23 April 2010

**RE: MP08_0112 – MIXED USE DEVELOPMENT AT LOTS 1-9 SECTION 9 DP
4209 AND LOT B IN DP 354297 – 7-9 GIBBONS STREET, REDFERN**

Joanne McGuinness
Director Planning and Urban Renewal

Figure 7 – William Lane elevation

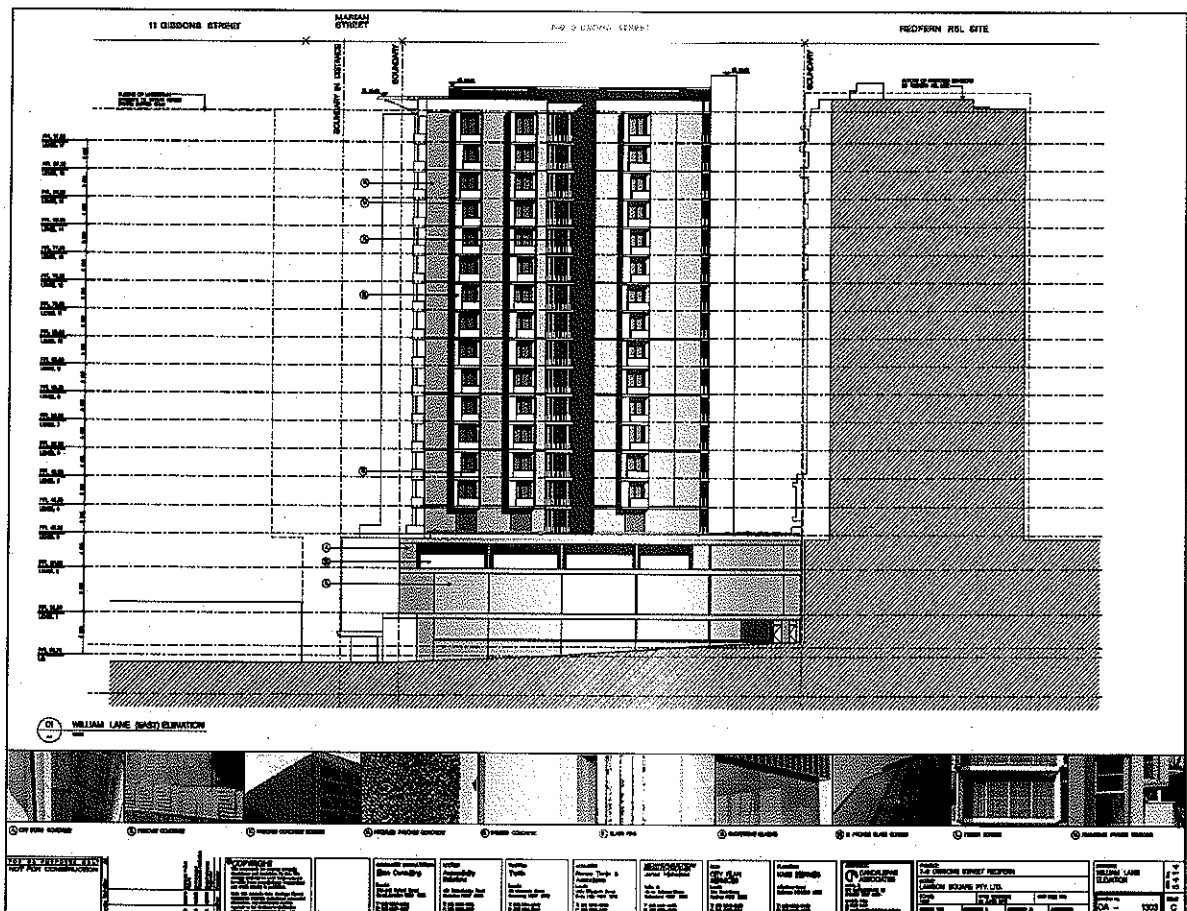
While the RWA have previously identified William Lane as potential vehicle access for future development and not major pedestrian access, the proposed treatment of this elevation is considered inappropriate. The inactive frontage is exacerbated by the selection of materials which present a completely blank facade to the laneway at street level. This proposed William Lane facade when combined with the large vehicle access proposed on Marian Streets results in large area of inactive building facade at street level, which is inconsistent with BEP 1 and the draft Redfern Centre Urban Design Principles.
